Our ref: DOC26/90163-12

13 March 2026

**EPA Advice on Environmental Impact Statement – Greater Parramatta, Olympic Peninsula
Water Cycle – SSI-74258485 (Part 2)**

I am writing in response to your request for the NSW Environment Protection Authority (EPA) to review the Environmental Impact Statement (EIS) for the proposed water resource recovery facility (WRRF) and associated infrastructure (Application SSI-74258485) at 9 Devon Street, Rosehill.

Figure 3-6e Indicative river release pipeline alignment

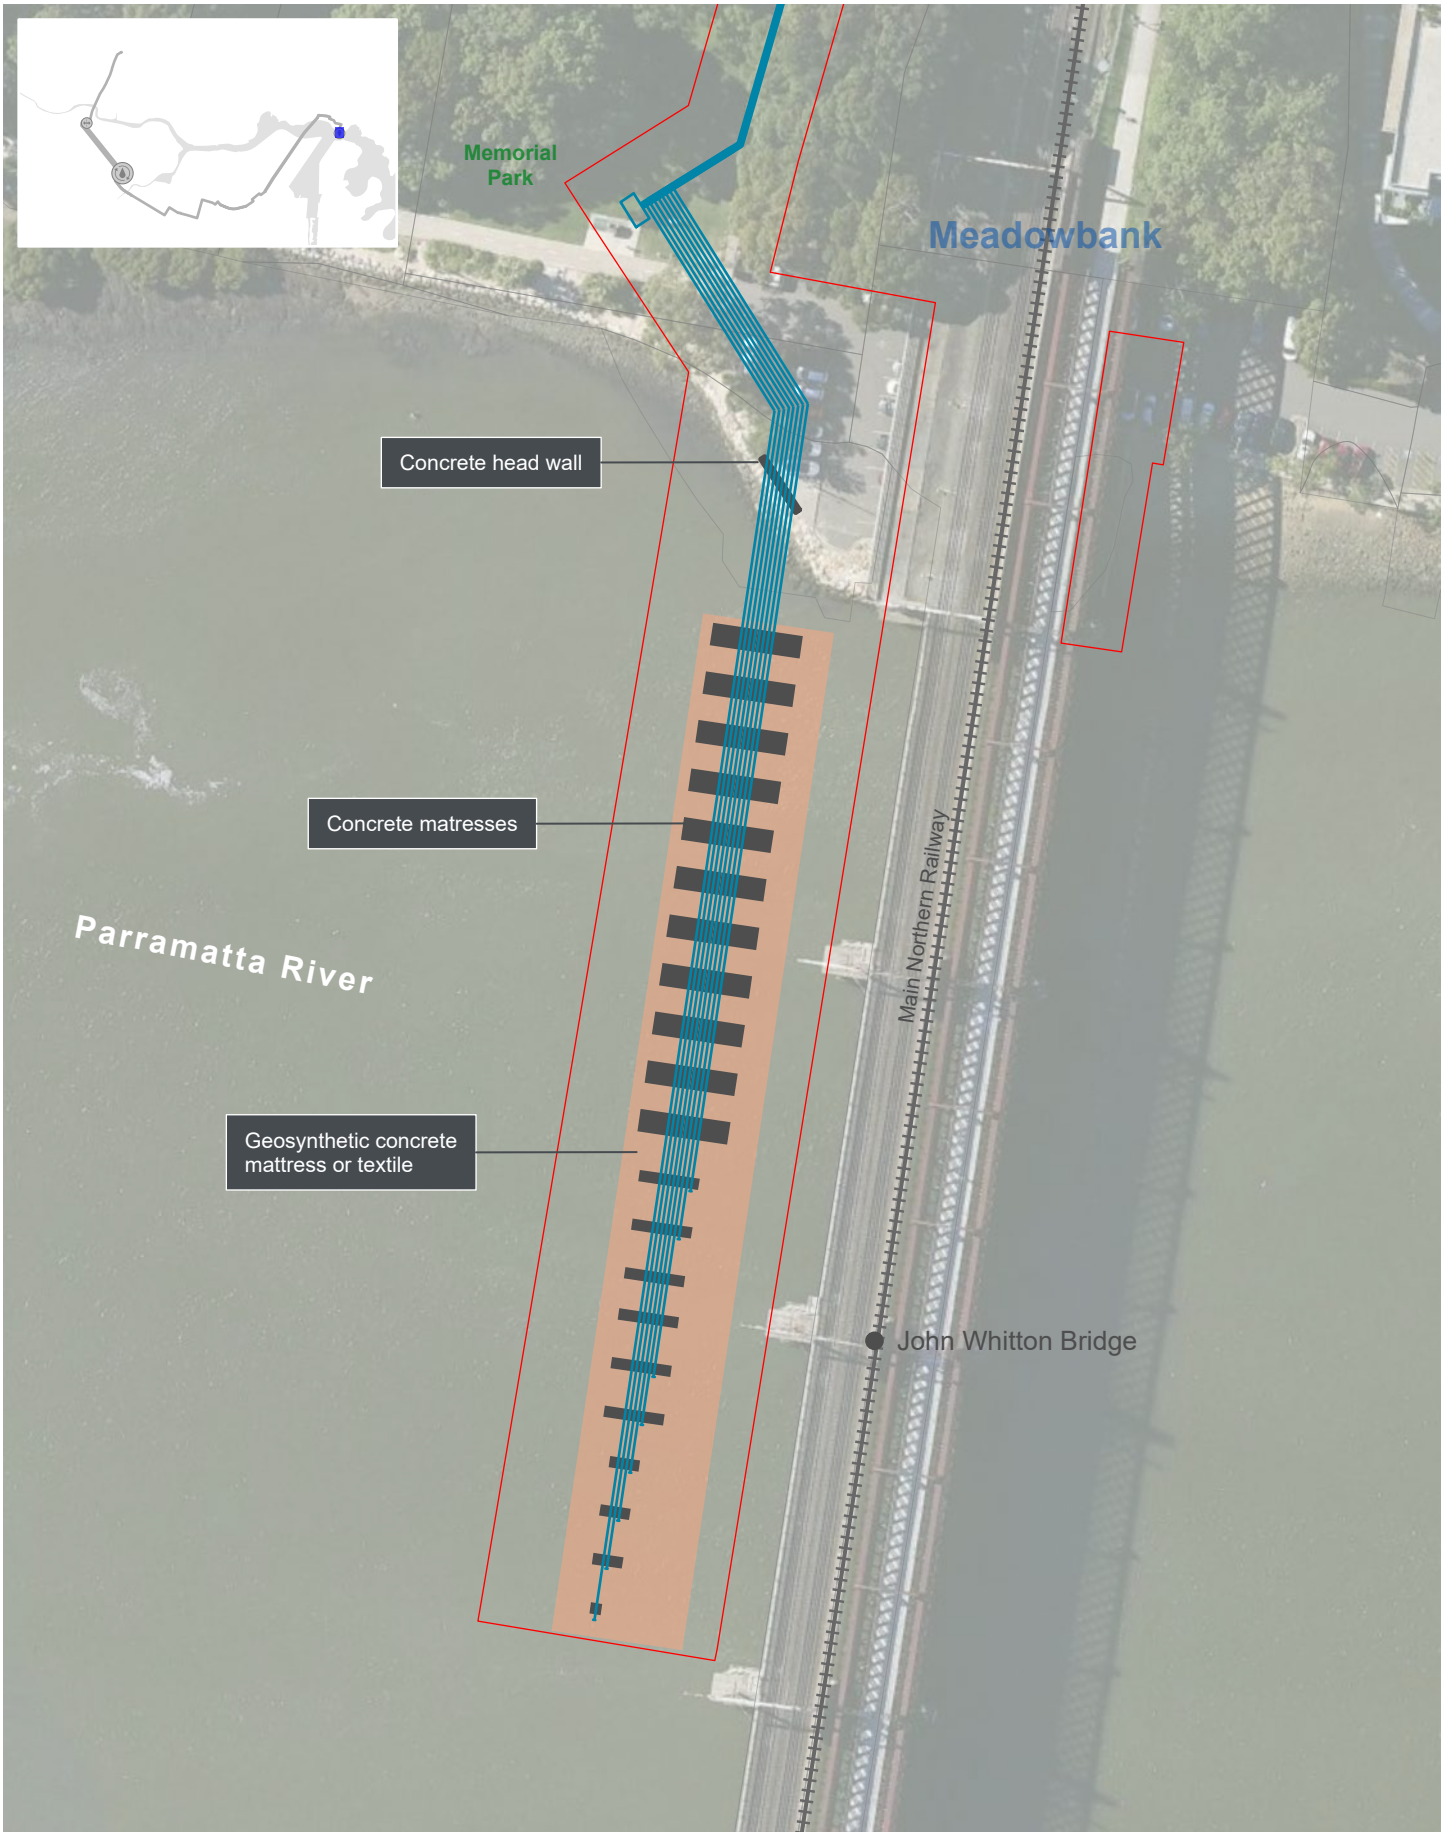
The EPA notes that there is potential for changes in water quality along the river release pipeline, most likely in relation to biological aspects.

The EPA requests that, in the detailed design of the water release pipeline, consideration is given to access for sampling to validate water quality at the end of the release pipeline prior to discharge.

Cadastre

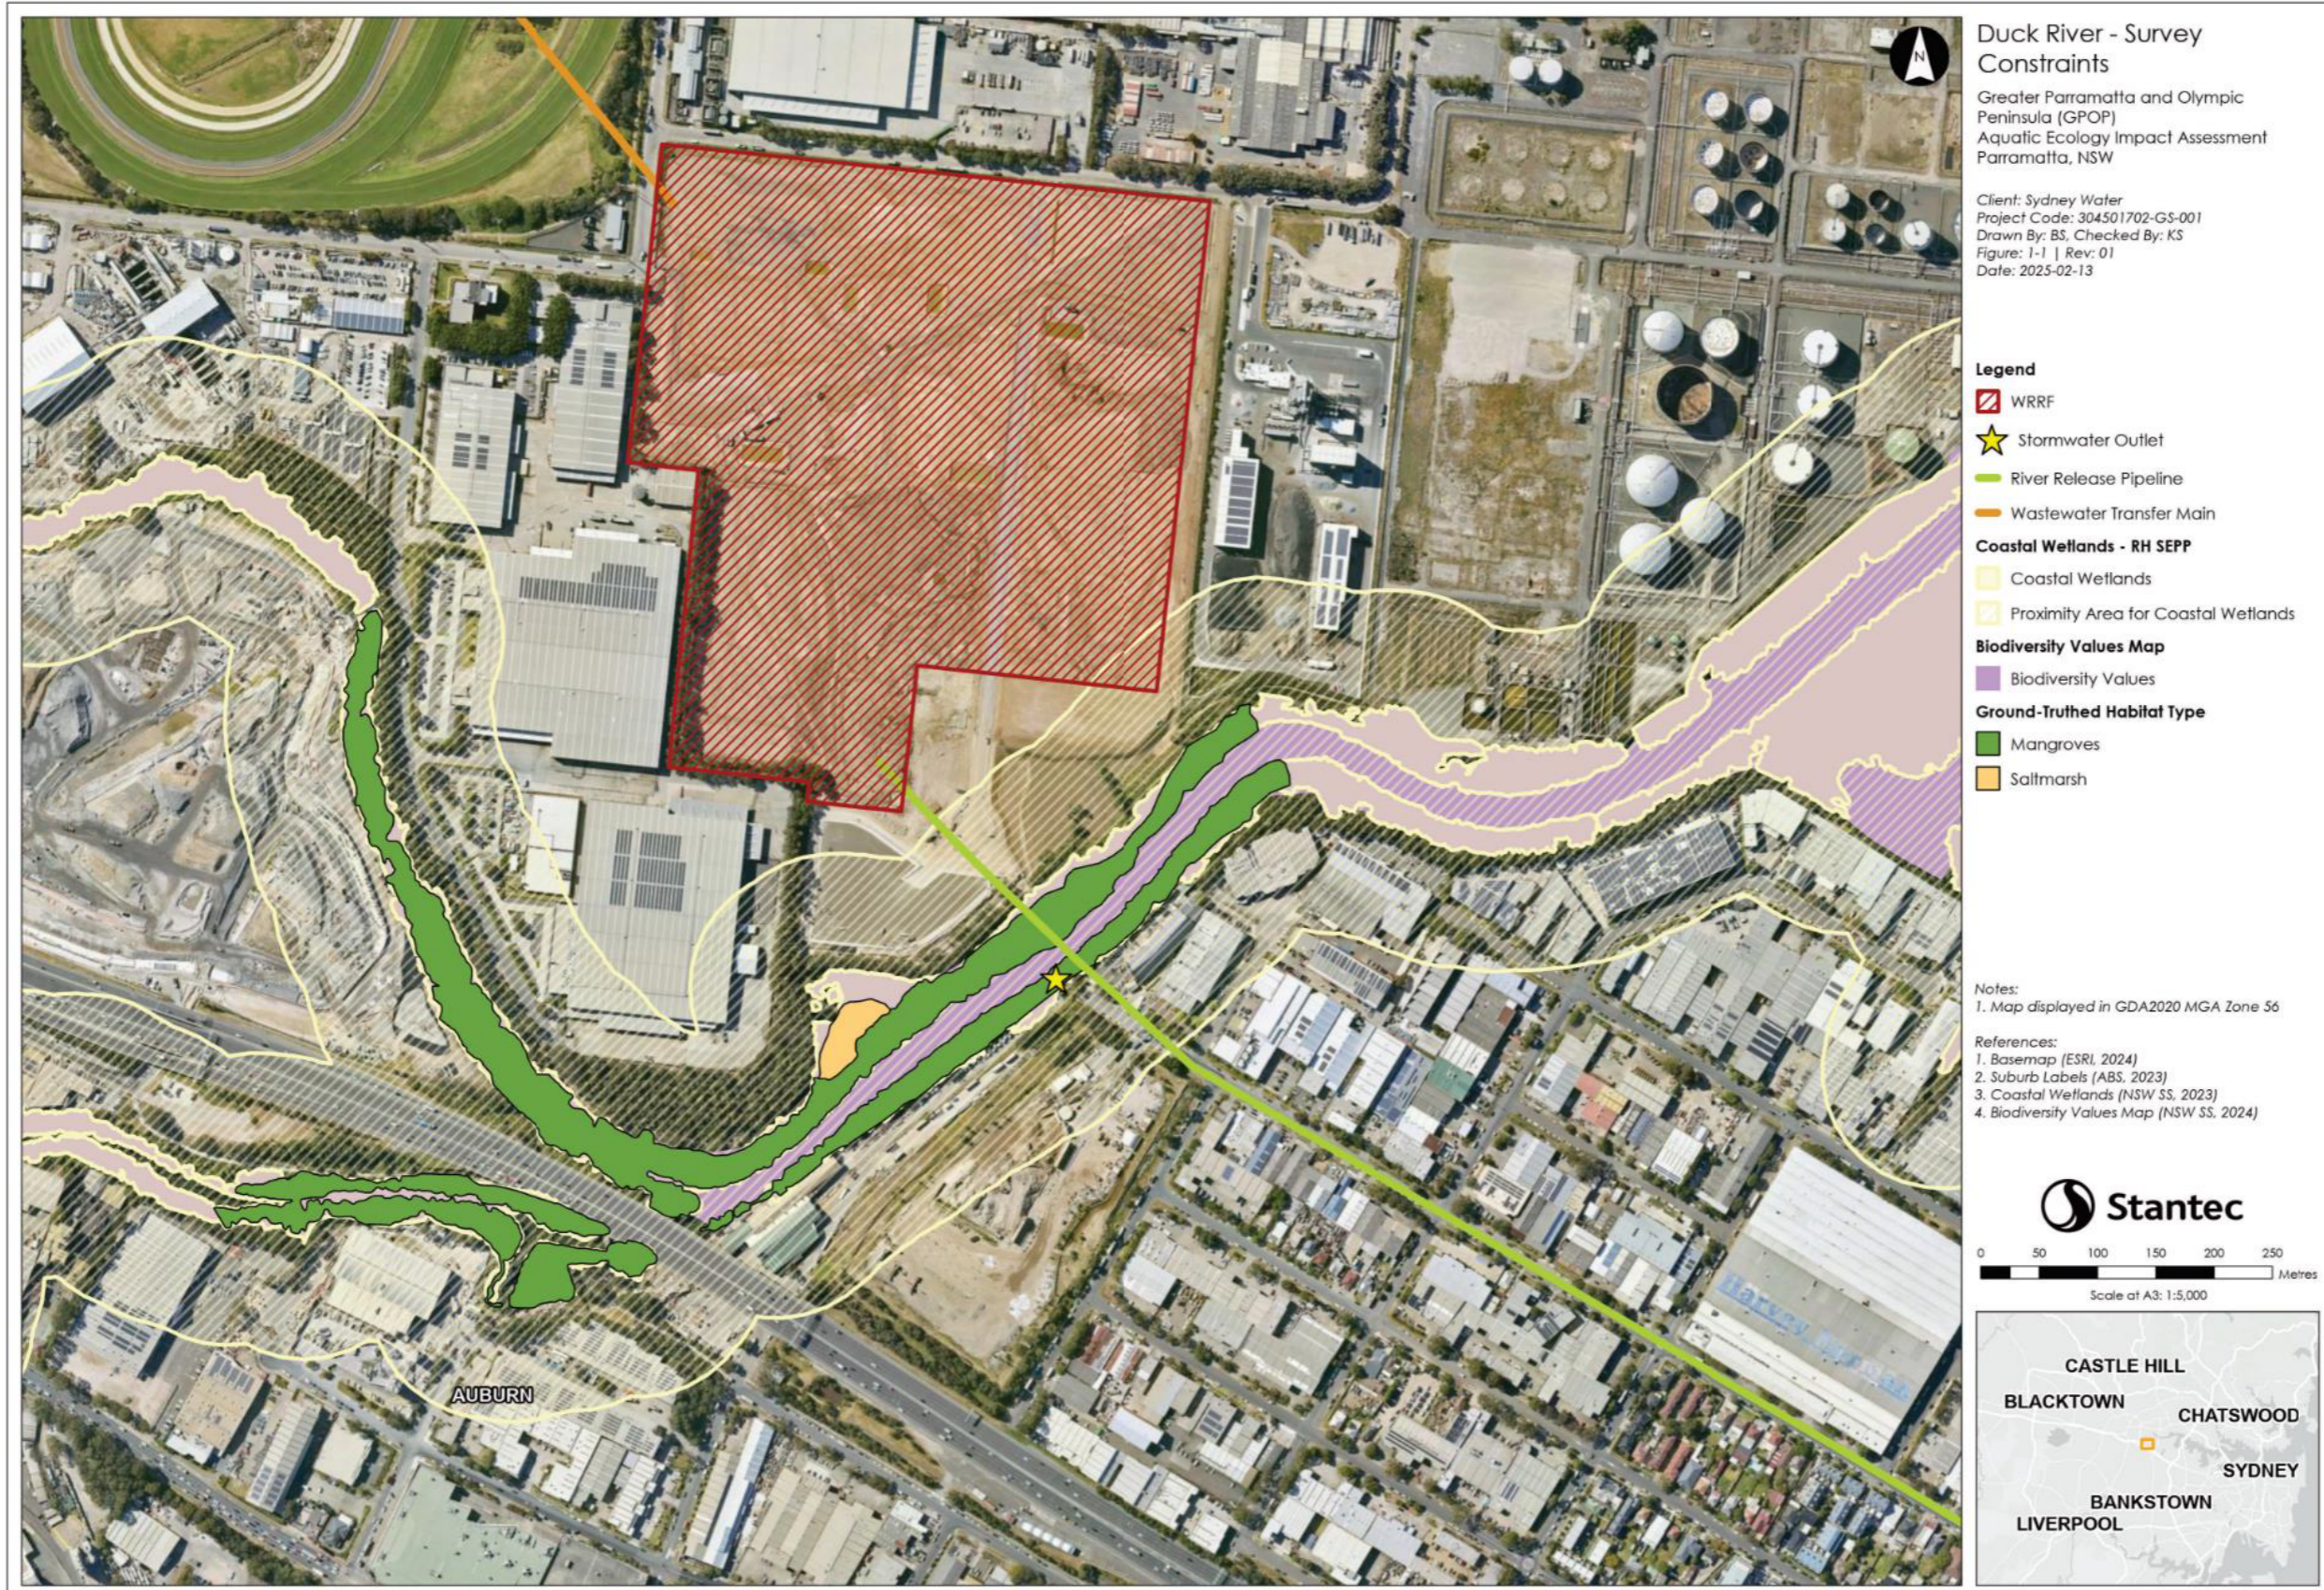
The proposed water quality monitoring related to works that may disturb sediment in the vicinity of John Whitton Bridge only includes visual checks of turbid plumes and monitoring once every 3 weeks at two locations (one upstream and one downstream) of the discharge point. However, sediment concentrations of zinc, dioxins and furans are elevated in the vicinity of the discharge, and their disturbance during construction should be appropriately monitored.

Turbidity should be continuously monitored close to the works, and zinc, dioxins and furans should initially be monitored weekly during construction to ensure mobilisation of contaminants is prevented and controlled with monitoring results being tied to predefined actions in a trigger action response plan (TARP).

The EPA requests that a riverbed construction activities trigger action response plan (TARP) is prepared as part of the project to prevent and control mobilisation of pollutants from contaminated sediments. The TARP must include, at a minimum:

- *reference to a water quality monitoring program for riverbed construction activities which includes but is not limited to:*
 - *continuous monitoring of turbidity at relevant depths*
 - *initially, weekly water sampling for dioxins, furans and zinc at the construction location(s) and at multiple locations downstream of the site. Monitoring frequency to be adjusted based on results for the first three weeks*
- *action-based trigger values for all key analytes and specific actions to occur based on the level of risk and exceedance of trigger values during riverbed construction activities, including, but not limited to, action-based trigger values for turbidity, dioxins, furans and zinc.*
